Application No: FG/163/21/PL
Site Address: The Chalet Littlehampton Road Ferring BN12 6PG
Description of works: Development comprising of marine workshop & boatyard, martial arts gym (Class E) & storage container compound (Class B8) to replace former glasshouses. This site is a Departure from the Development Plan & is in CIL Zone 3 (Zero Rated) as other development.

Thank you for your internet representation made on 19th October 2021 which has been recorded as an objection with the comments as follows:

SITE PLAN 1:500 @ A3

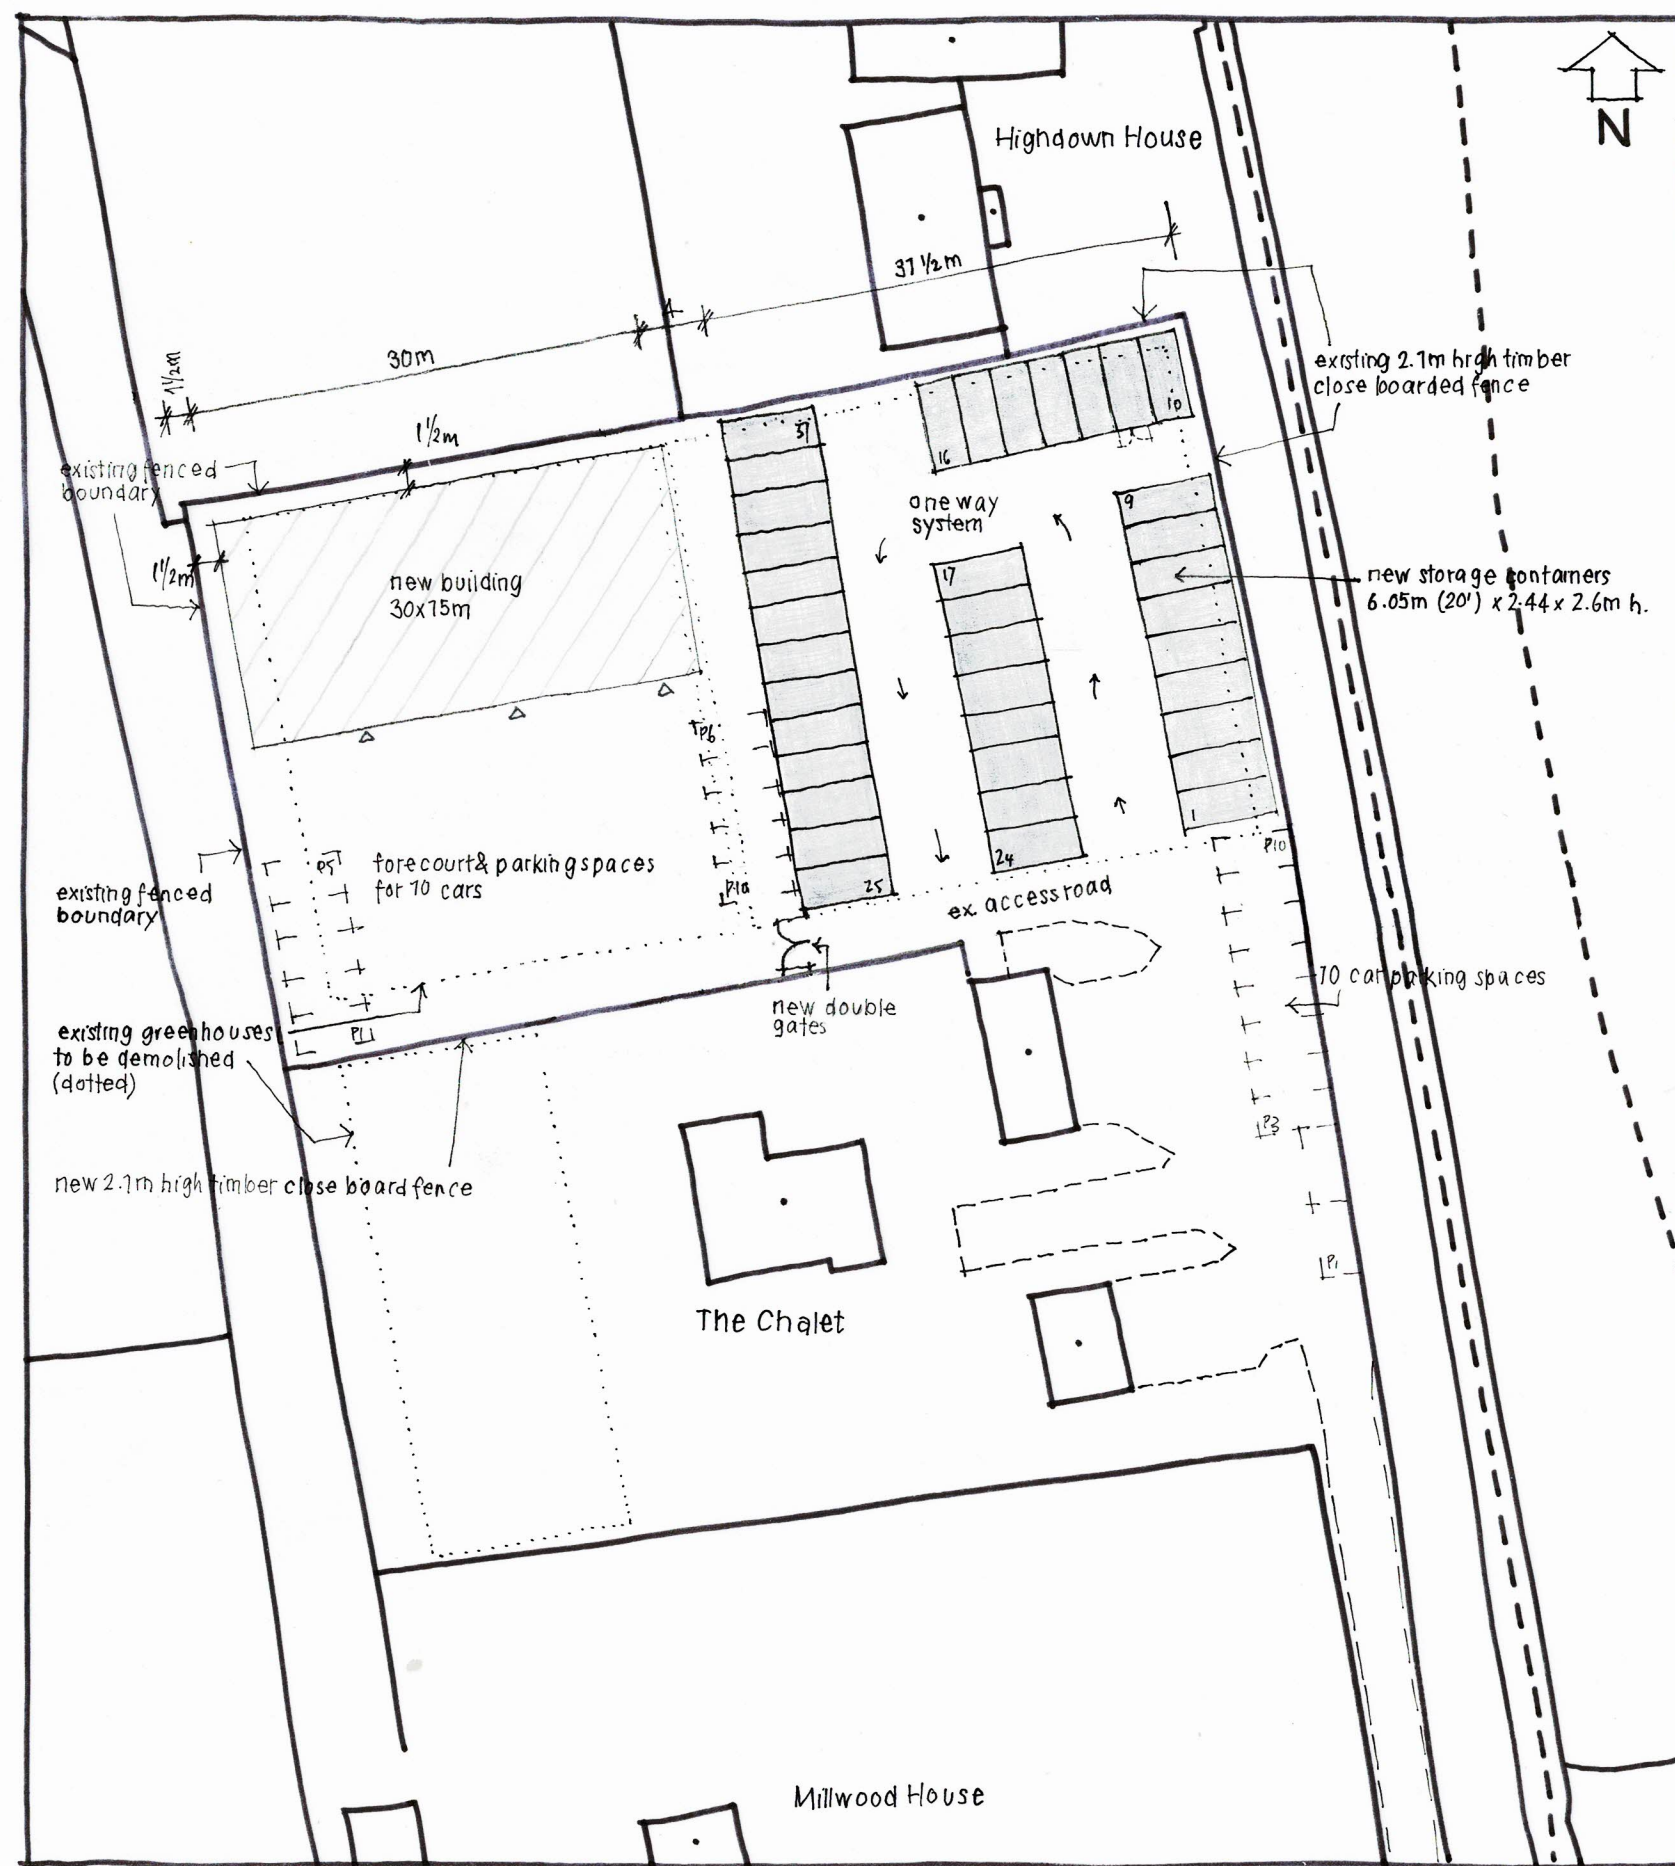
The proposed entrance is a shared driveway, it is my belief that the applicant has used some sleight of hand tactics to make it look like they have an oversized entrance, when in fact I would go as far as saying it is undersized and dangerous.

The application for a marine boatyard and workshop has been put forward without the proper research and planning, the proposed site location is completely not suitable for the proposal. The A259 is a fast road with a speed limit of 50mph, the turn onto the site is sharp and completely dangerous. AVS fencing and others have refused permission for the applicant to use their access road, which means any commercial vehicles looking to gain access to the site would need to do so from the outside lane and swing across the inside lane to access, and even then it would be very tight if not impossible to do without crossing the access road they have been refused access to.

Taking a standard transit van with dimensions of 19'6"ft length and 6'0"ft width and a very standard boat trailer that on average is a length of 22'30"ft that gives off on average a combined length of 41'90"ft (12.77m). This is using standard averages and not including that on average most of these trailers will in actual fact be manoeuvring a boat larger than the actual trailer and would therefore have a significant overhang to also deal with.

Now when you consider a standard highway road has a width of 12'13"ft, if the applicant were to bring in a boat on a standard transit with an average trailer you would be looking at an outward swing of close to 2ft into the outside line, maybe more.
